Application No: EP/5/21/HH
Site Address: Shore House Seafield Road East Preston BN16 1NA
Description of works: Detached garage extension with new pitched roof to create first floor self contained annexe & detached office outbuilding.

OWPC34184

I am commenting on behalf of the East Preston and Kingston Preservation Society.

PROPOSED FIRST FLOOR PLAN 1:50

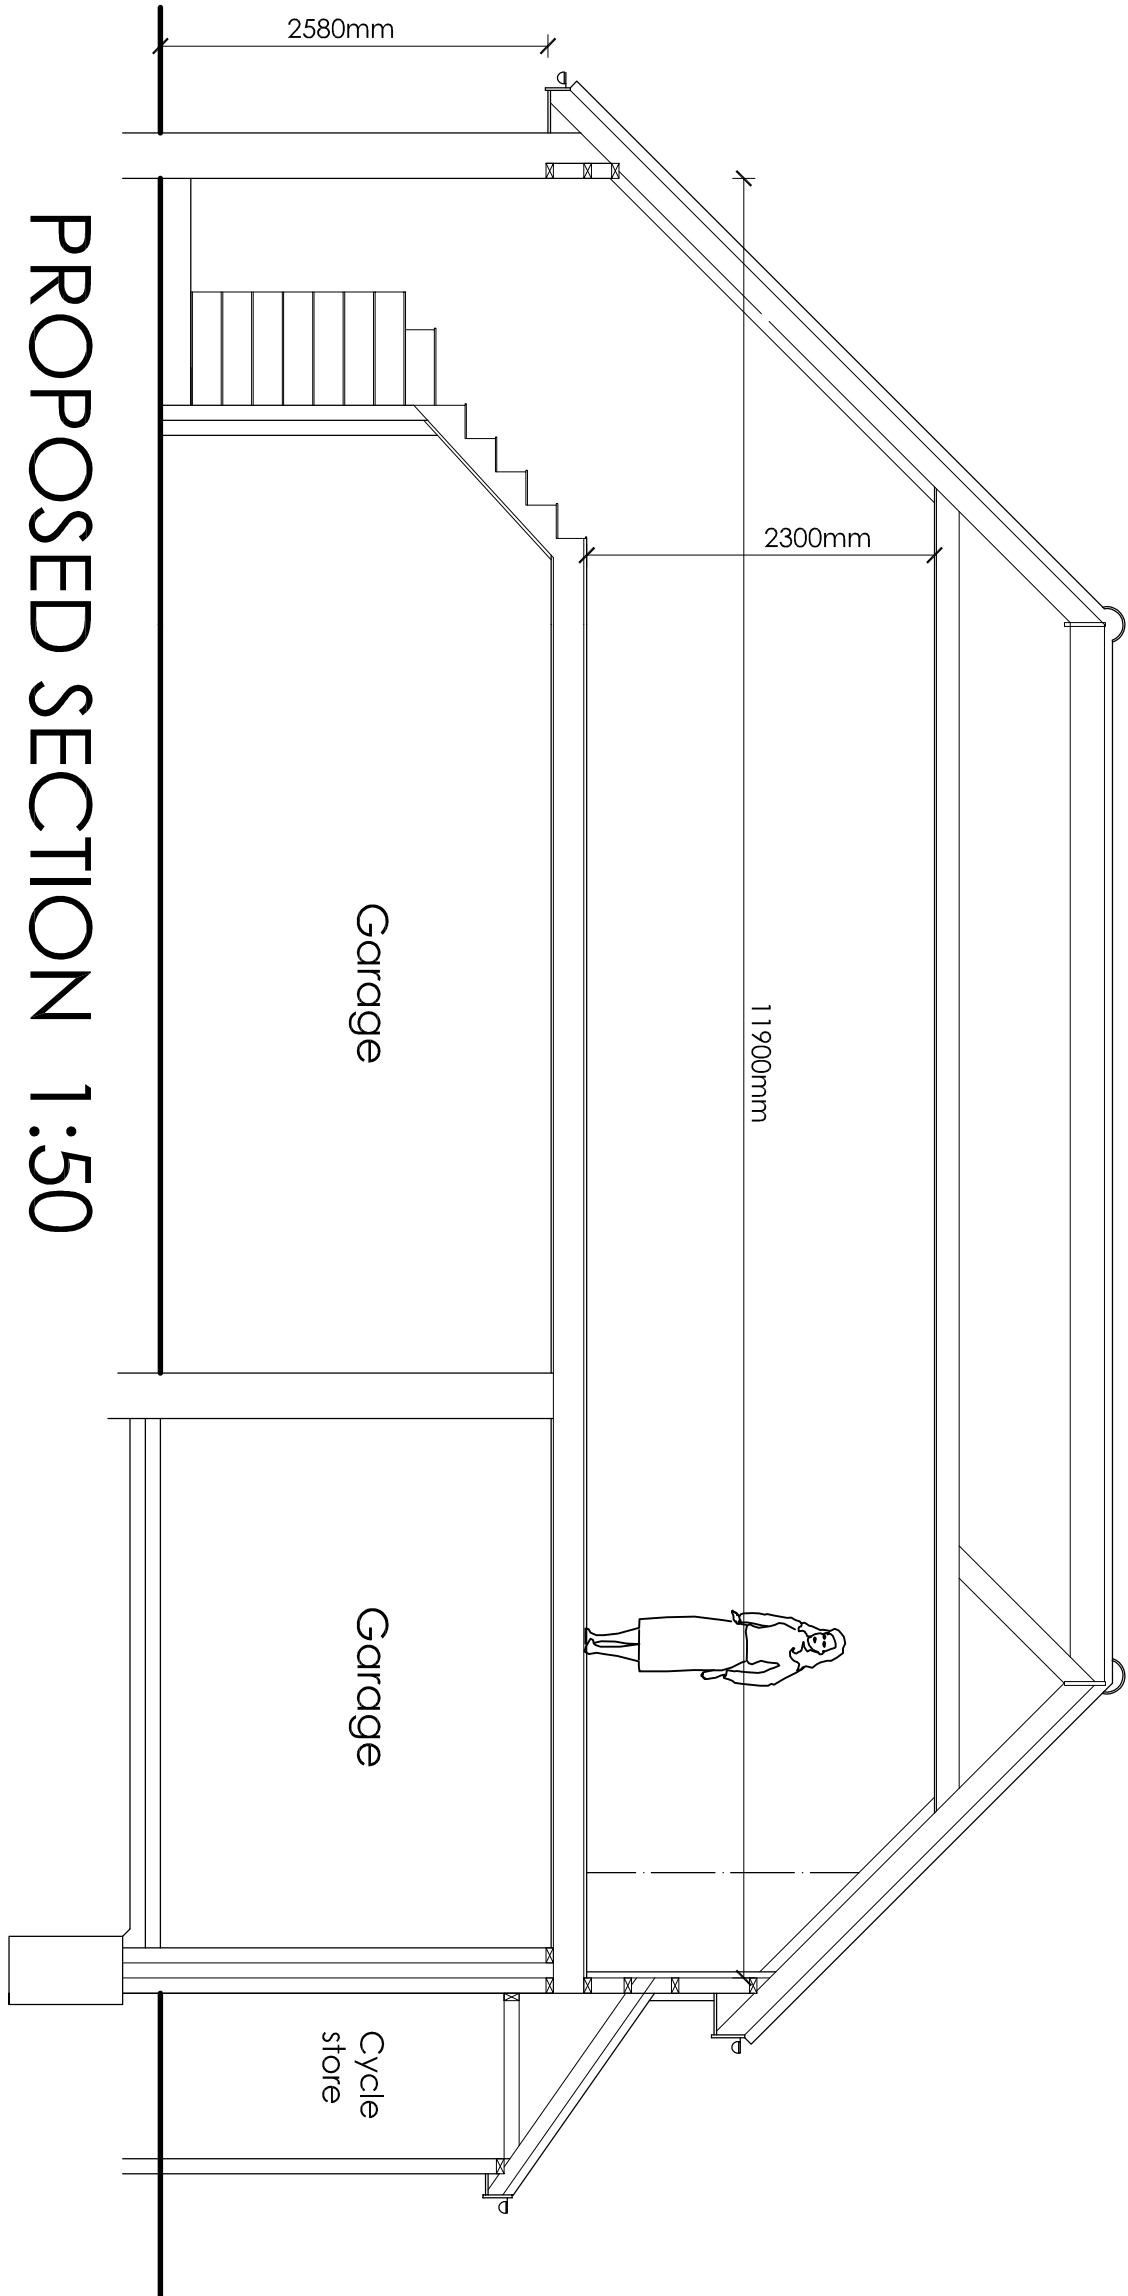
This development would place a two storey building 2.8 metres from the front boundary of the plot. The street frontage of the building would be especially unattractive, featuring the bin storage and the cycle shed. The building, because of its position, would have a significantly harmful effect on the street scene.

SITE PLAN 1:500

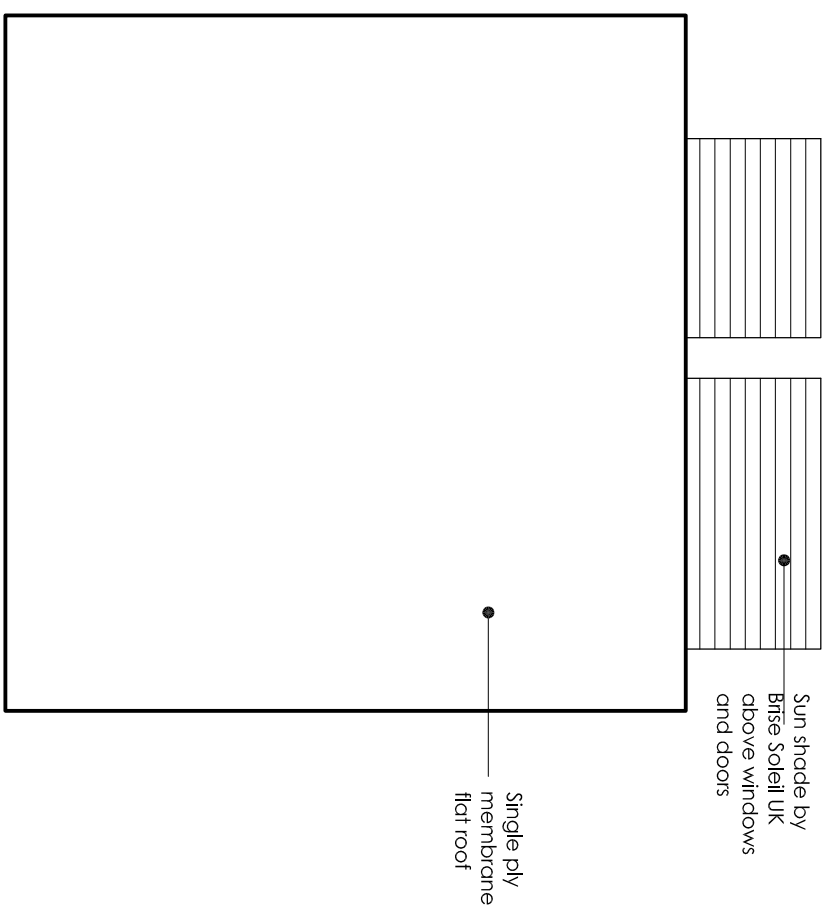
The construction of a two storey building 2.8 metres from the edge of the road would destroy this sense of space, and so do significant harm to the character of the road.
